CITY OF ALBUQUERQUE

May 23, 2024

**Re: Cuba Botanicals LLC Grow Facility
5904 Florence NE, Albuquerque, NM 87113
Traffic Circulation Layout
Engineer's/Architect's Stamp 5/22/2024 (B18D030)**

**OVERALL SITE PLAN / CLEAR SIGHT TRIANGLE /
SIGNAGE DETAILS**

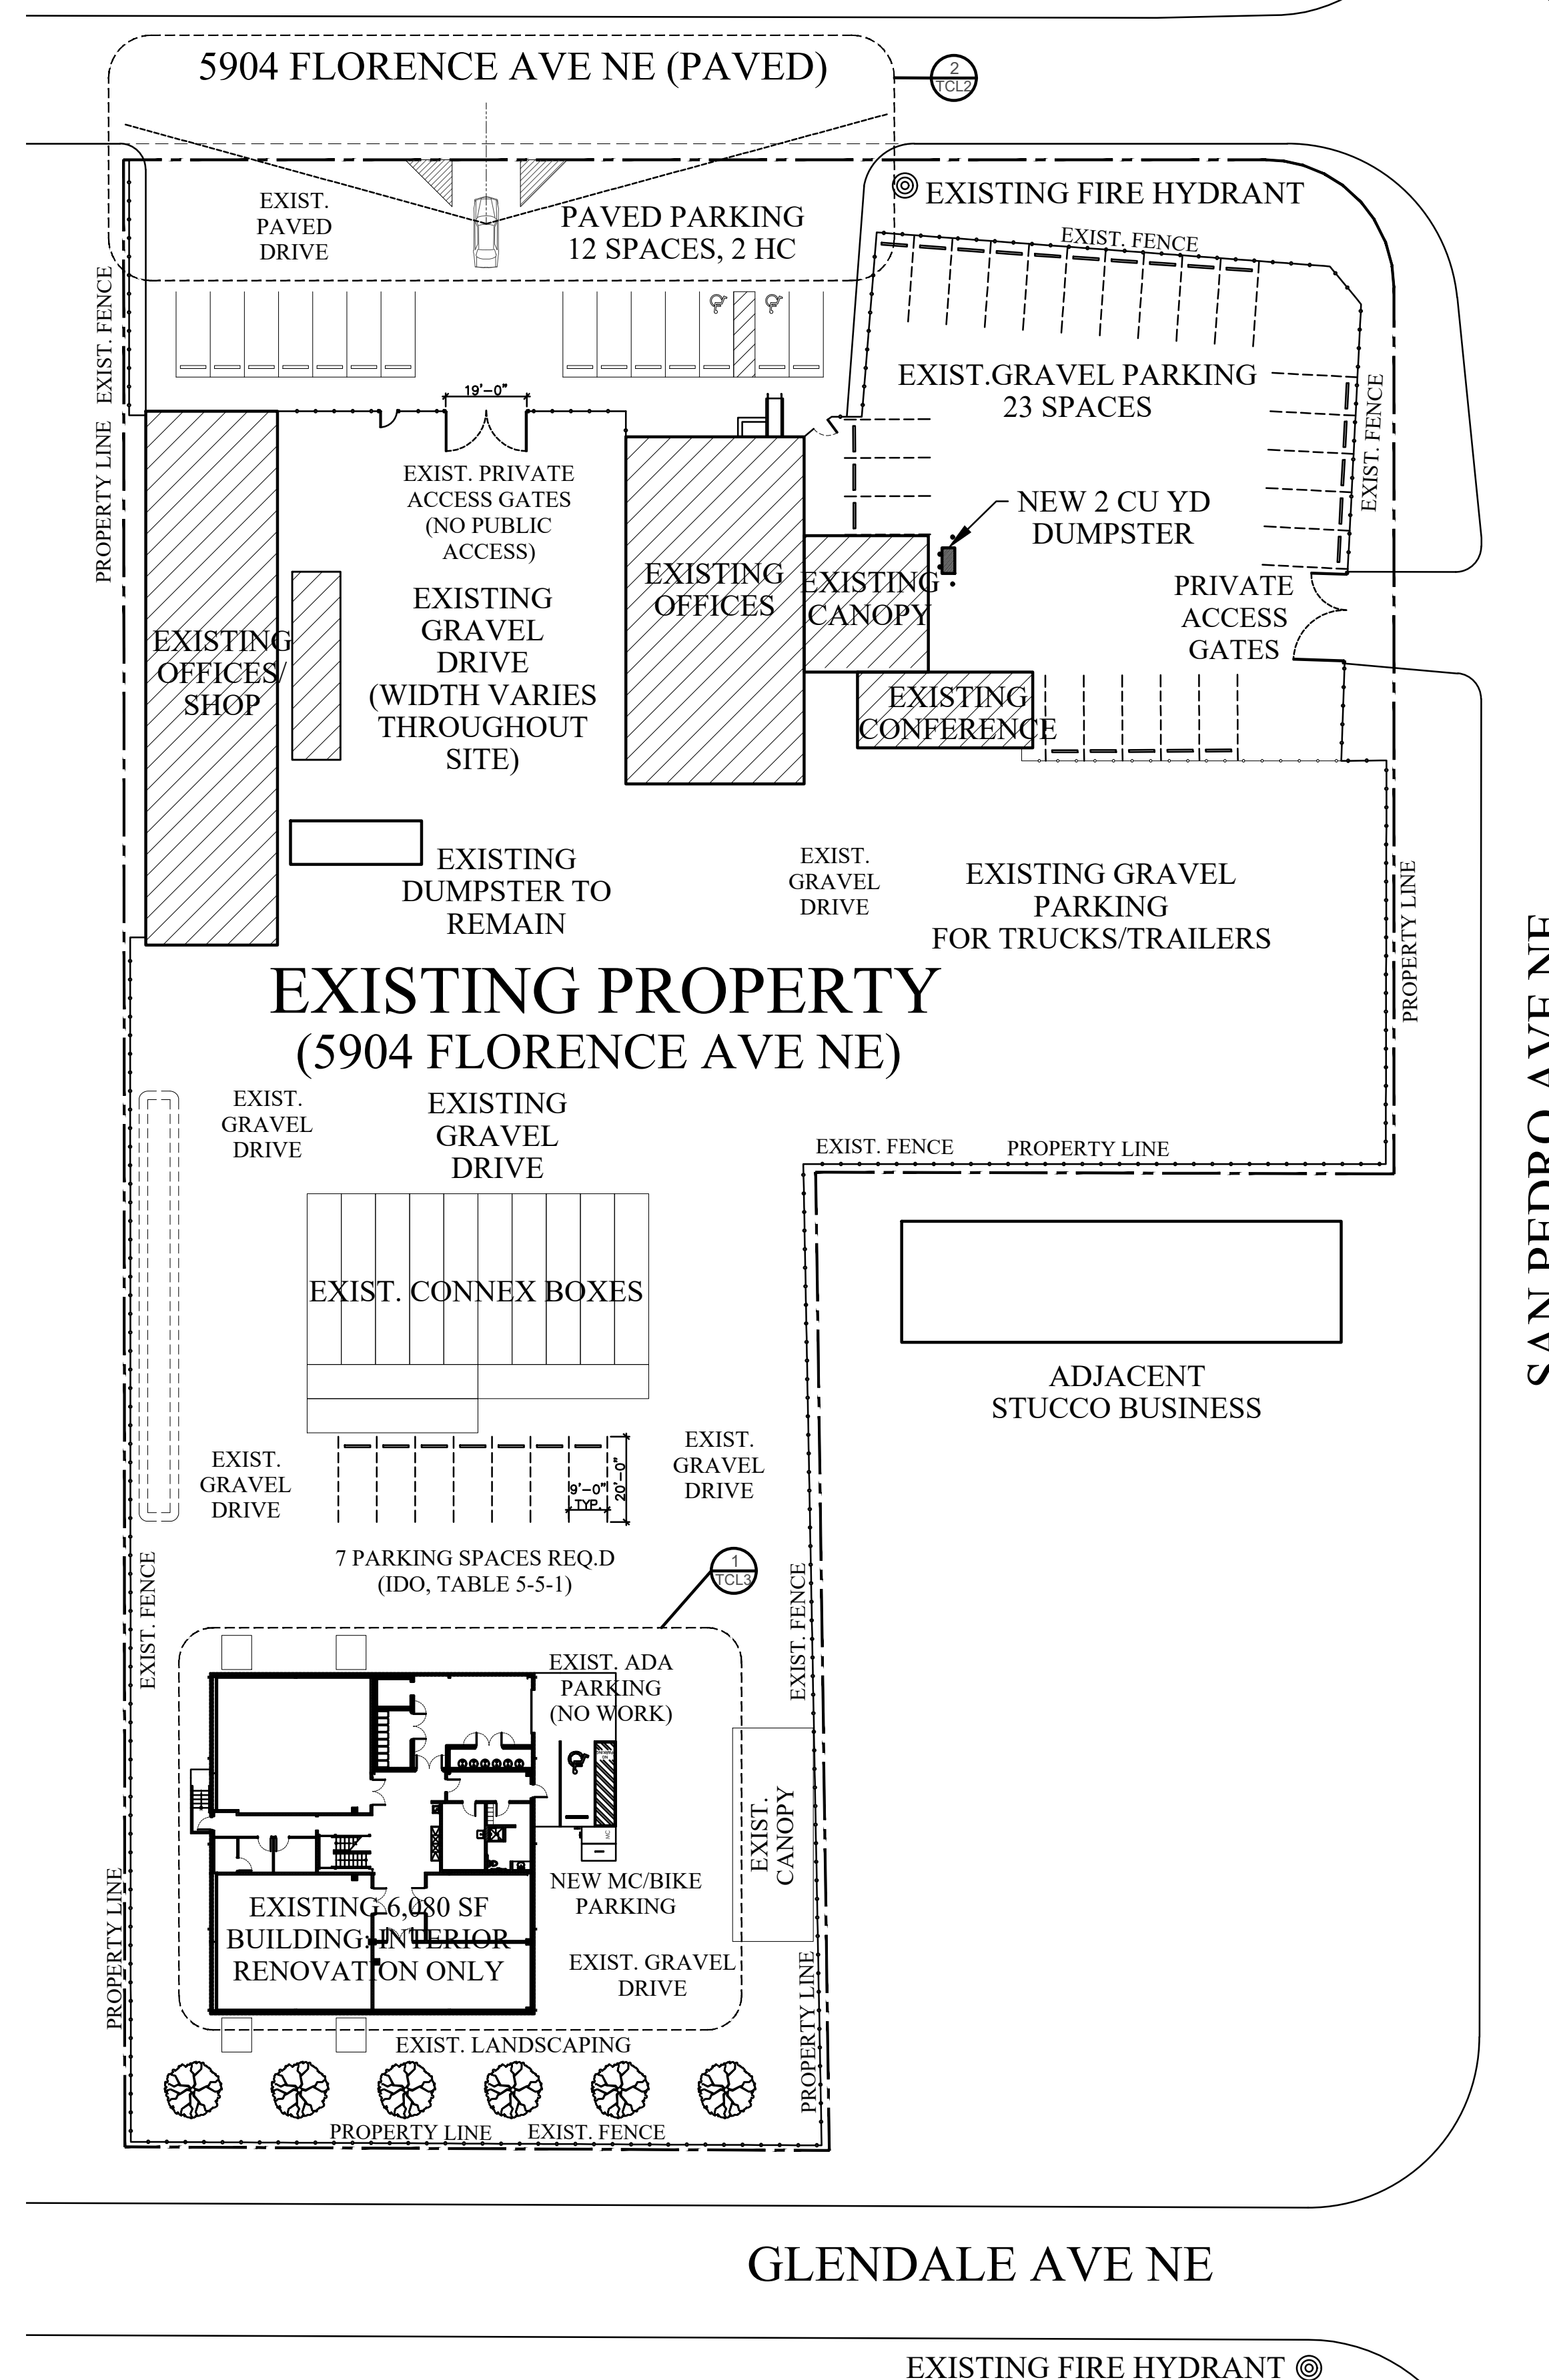
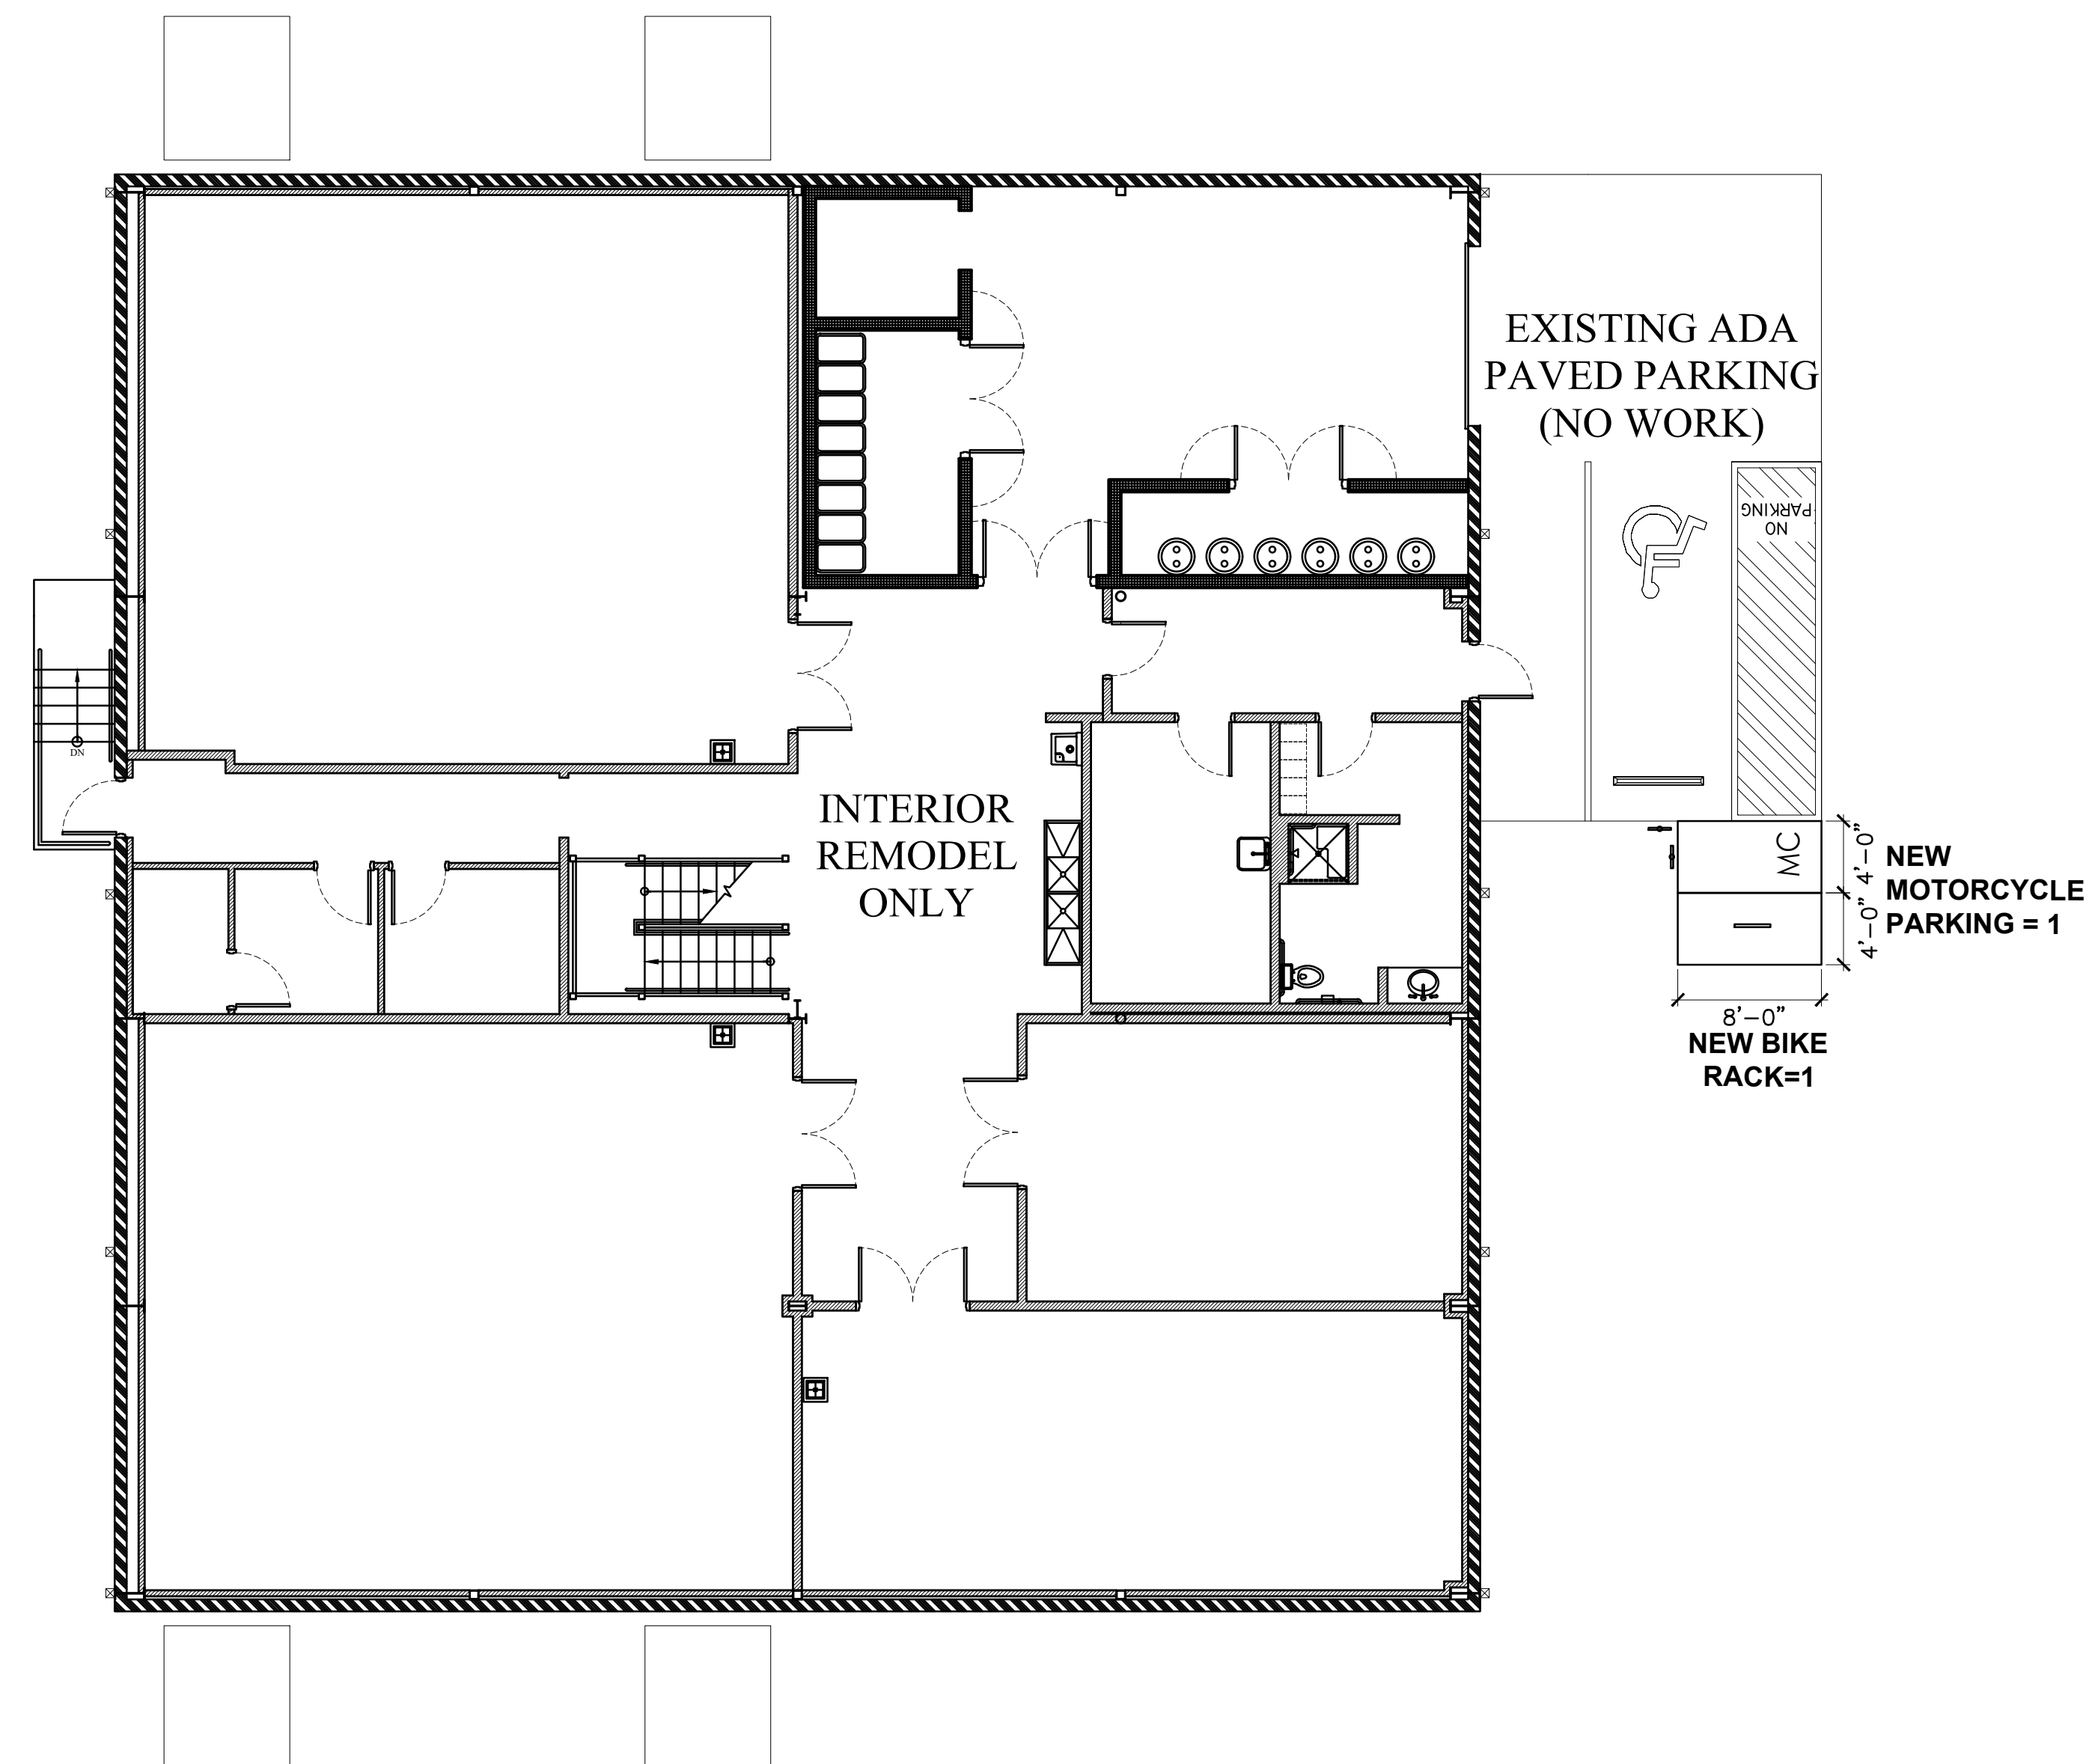
3. All accessways to the site from the adjacent roadway shall be ADA-compliant. Gravel path is not acceptable.
4. Show the dimensions of the existing H.C. parking, this should be for van parking with 8 ft wide van access aisle

6. Show all drive aisle widths and radii.
7. The minimum drive aisle dimensions are shown below

Minimum Drive Aisle Width
Two Way Traffic	22'
Main Circulation Road	24'
Fire Lane	20'

8. Per DPM, a 6 ft. wide ADA accessible pedestrian pathway is required from the ADA parking stall access aisles to the building entrances. Please clearly show this pathway and provide details.
9. Curbing should be installed to delineate landscape, parking, and pedestrian ways and identify points of access. Please call out detail and location of barrier curb.
10. Refuse vehicle maneuvering shall be contained on-site. The refuse vehicle shall not back into the public right of way.; provide a copy of refuse approval.
11. All one-way drives shall have "One Way" and "Do Not Enter" signage and pavement markings. Please show detail and location of posted signs and striping.
12. If you are using Florence Ave as your entrance, you need an access easement from the owner of the property to your north and install sidewalk along Florence.
